May 11, 2017

Re: **Crown Castle applications for installation of telecommunications equipment within the public ways of the City of Mercer Island (the “City”)**  
**ROW Permit Application Nos. 1701-126 through 1701-132;**  
**1701-134 through 1701-136; and 1701-138 through 1701-166 (the “Applications”)**

MIS12

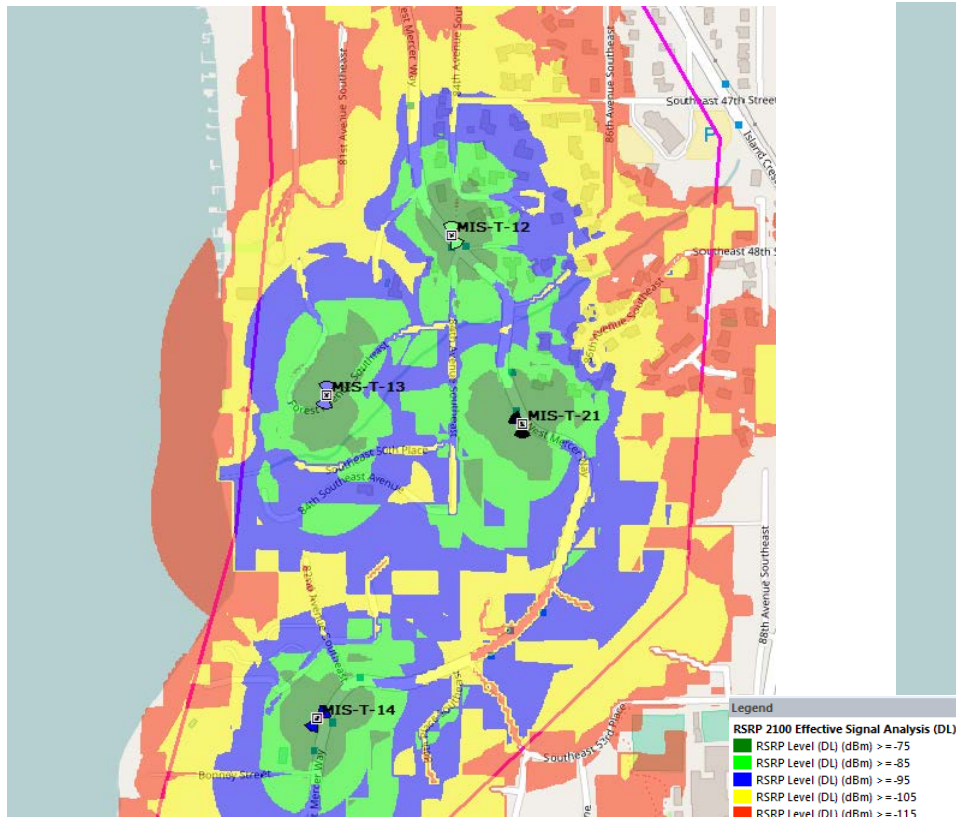
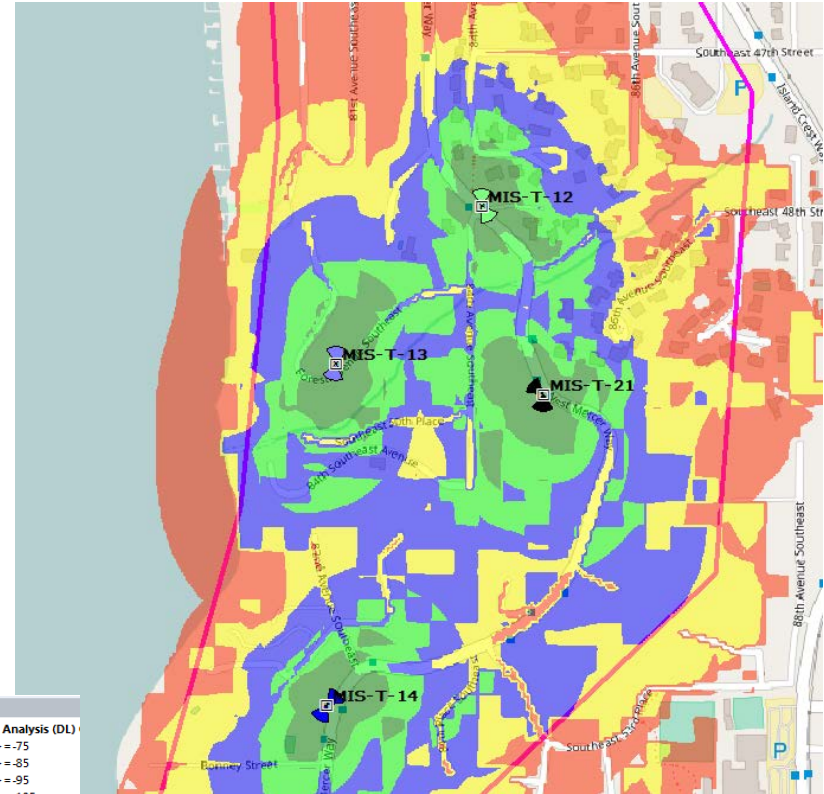
MIN13	1701-139	Alternate Pole 1 is 195' from the selected pole. Alternate Pole 2 is 190' from the selected pole.
MIS02	1701-143	Alternate Pole 1 is 250' from the selected pole. Alternate Pole 2 is 160' from the selected pole. Neither Alternate Poles 1 nor 2 will propagate to fill the significant gap in coverage. Please see attached propagation map.
MIS12	1701-153	Alternate Poles 1 – 3 are all 120' or more from the selected pole. Alternate Pole 3 would require significant tree pruning. Alternate Pole 4 will not propagate to fill the significant gap in coverage. Please see attached propagation map.
